Located At 25 LENNOX ST

Job ID: 2012-08-4806-ALTR

Job No: 2012-08-4806-ALTR 2012-50253-AMEND	Date Applied: 11/15/2012	CBL: 430- A-007-001		
Location of Construction: 25 LENNOX ST	Owner Name: ALLISON BROWN	Owner Address: 25 LENNOX ST PORTLAND, ME 04103	Phone: 207-650-9756	
Business Name:	Contractor Name: Rush Brown	Contractor Address: 125 Newbury St., Portland, ME 04101	Phone: 207-650-6204	
Lessee/Buyer's Name:	Phone:	Permit Type: Building	Zone: R-3	
Past Use: Single family	Proposed Use: Same – single family amend permits #2012-07-4408, 2012- 08-4665 & #2012-08-4806 – changing staircase to attic to spiral staircase	Cost of Work: \$2,000.00	CEO District:	
		Fire Dept: <input type="checkbox"/> Approved <input checked="" type="checkbox"/> Denied <input type="checkbox"/> N/A	Inspection: Use Group: R3 Type: SB IRC 2009 Signature: <i>[Signature]</i>	
Proposed Project Description: change attic staircase to spiral staircase		Pedestrian Activities District (P.A.D.)

Jonathan Rioux - RE: Fwd: Lennox 25 House - Spiral Stair Floor Framing Details

A ATTIC FLR FRAMING PLAN AT SPIRAL STAIR -11/24/12
 Scale: 3/16" = 1'-0"

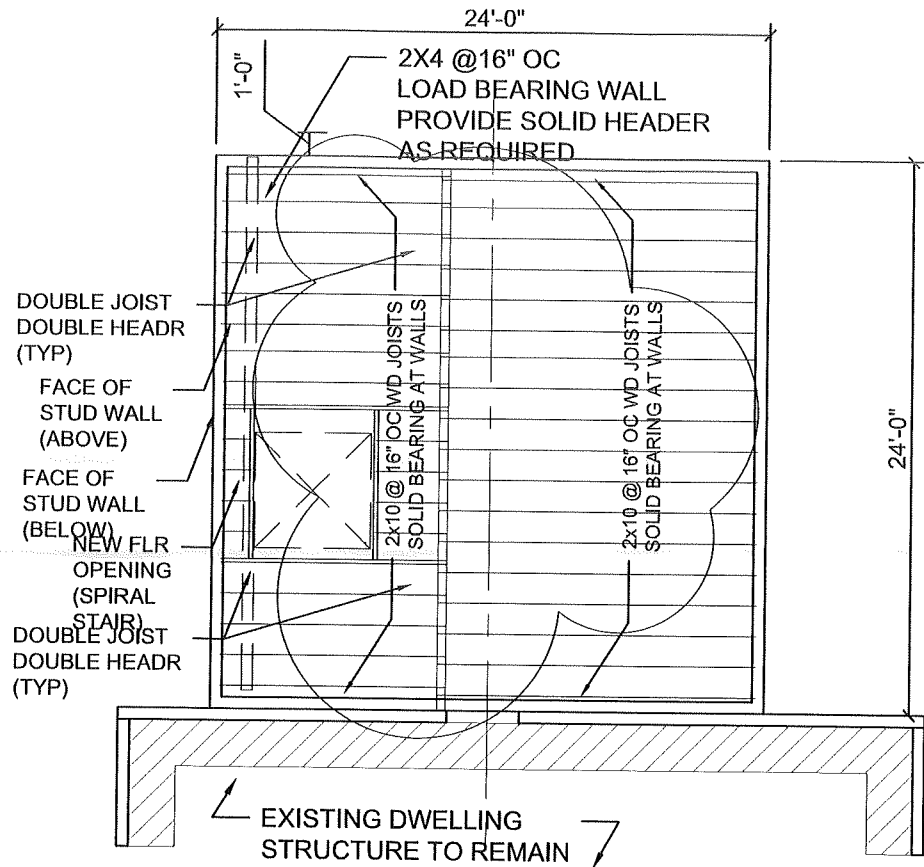
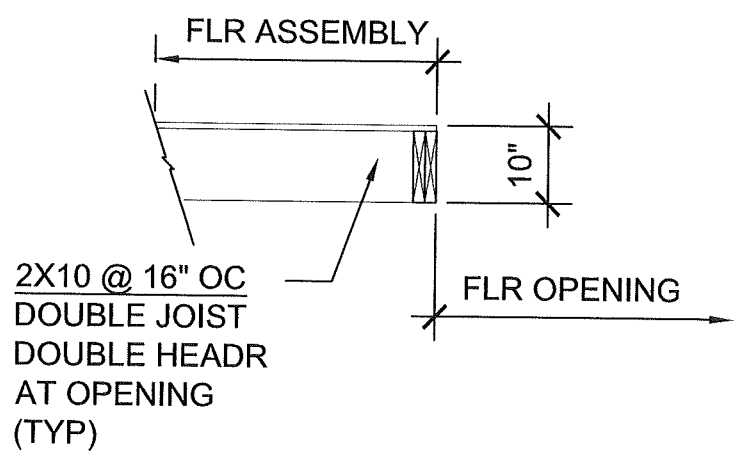
- What did you design the live load for the "attic storage" area?
- Is there an emergency escape for the habitable attic area?

R502.3.1 Sleeping areas and attic joists. Table R502.3.1(1) shall be used to determine the maximum allowable span of floor joists that support sleeping areas and attics that are accessed by means of a fixed stairway in accordance with Section R311.7 provided that the design live load does not exceed 30 pounds per square foot (1.44 kPa) and the design dead load does not exceed 20 pounds per square foot (0.96 kPa). The allowable span of ceiling joists that support attics used for limited storage or no storage shall be determined in accordance with Section R802.4.

ATTIC, HABITABLE. A finished or unfinished area, not considered a story, complying with all of the following requirements: 1. The occupiable floor area is at least 70 square feet (17 m²), in accordance with Section R304, 2. The occupiable floor area has a ceiling height in accordance with Section R305, and 3. The occupiable space is enclosed by the roof assembly above, knee walls (if applicable)

SECTION R310 EMERGENCY ESCAPE AND RESCUE OPENINGS R310.1 Emergency escape and rescue required. Basements, **habitable attics** and every sleeping room shall have at least one operable emergency escape and rescue opening...

- LL=40 psf (SPF #2 or better) (2x10 @16 OC w/ DL = 10psf)
- Yes, emergency escape is provided (second story/glazed window). The primary occupancy use of the Attic area is storage for Mr. Brown's artwork. Furthermore, it's my understanding that the new house will be fully sprinklered in accordance with NFPA-13R as required by the City's FP rules. Note: By building code ruling, Emergency escape is except for habitable spaces when the building is sprinklered, nevertheless windows are being provided at two sides: a)one unit at end gable wall (approx. 3x5 ft RO size window) and a triple dormer wall (approx. 9x3 ft RO size window)

SPIRAL STAIR
12 EQUAL TREADS
13 EQ. RISERS @
9.23-IN = 10'-0"

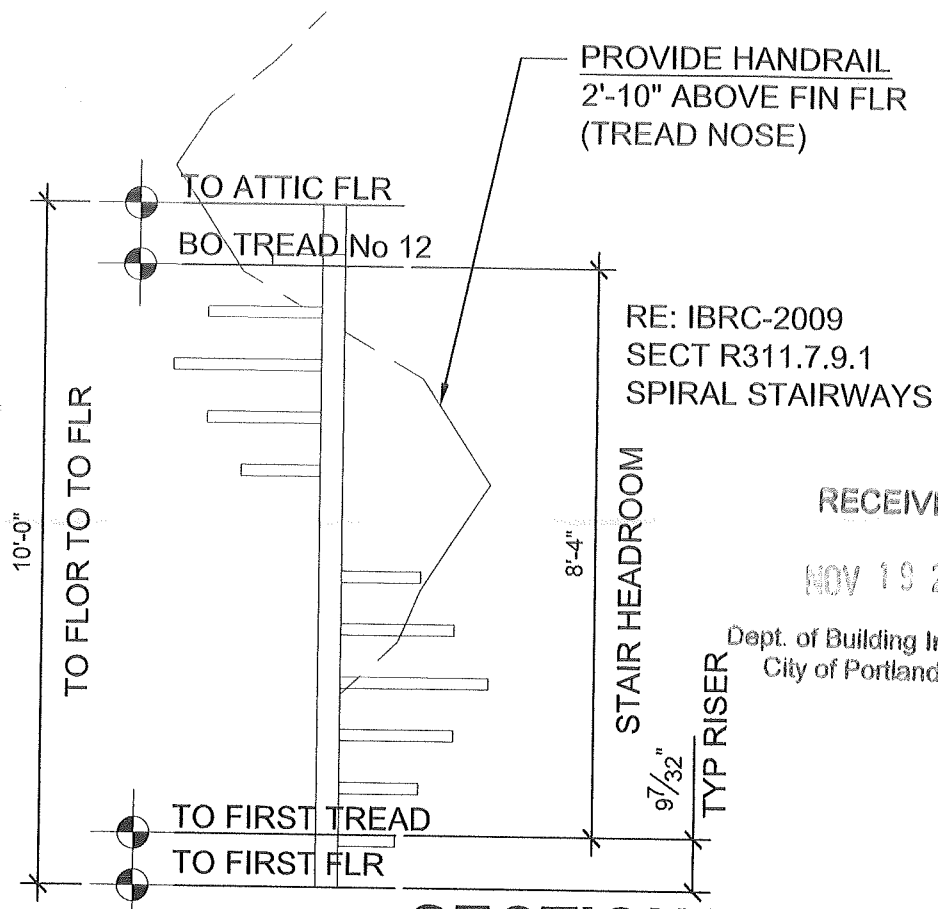
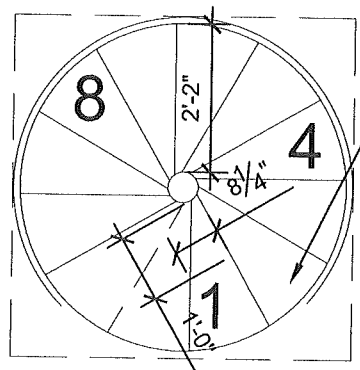
3. R311.7.9.1 Spiral stairways. Spiral stairways are permitted, provided the minimum clear width at and below the handrail shall be 26 inches with each tread having a 7 1/2-inch minimum tread depth at 12 inches from the narrower edge. All treads shall be identical, and the rise shall be no more than 9 1/2 inches. A minimum headroom of 6 feet 6 inches (1982 mm) shall be provided.
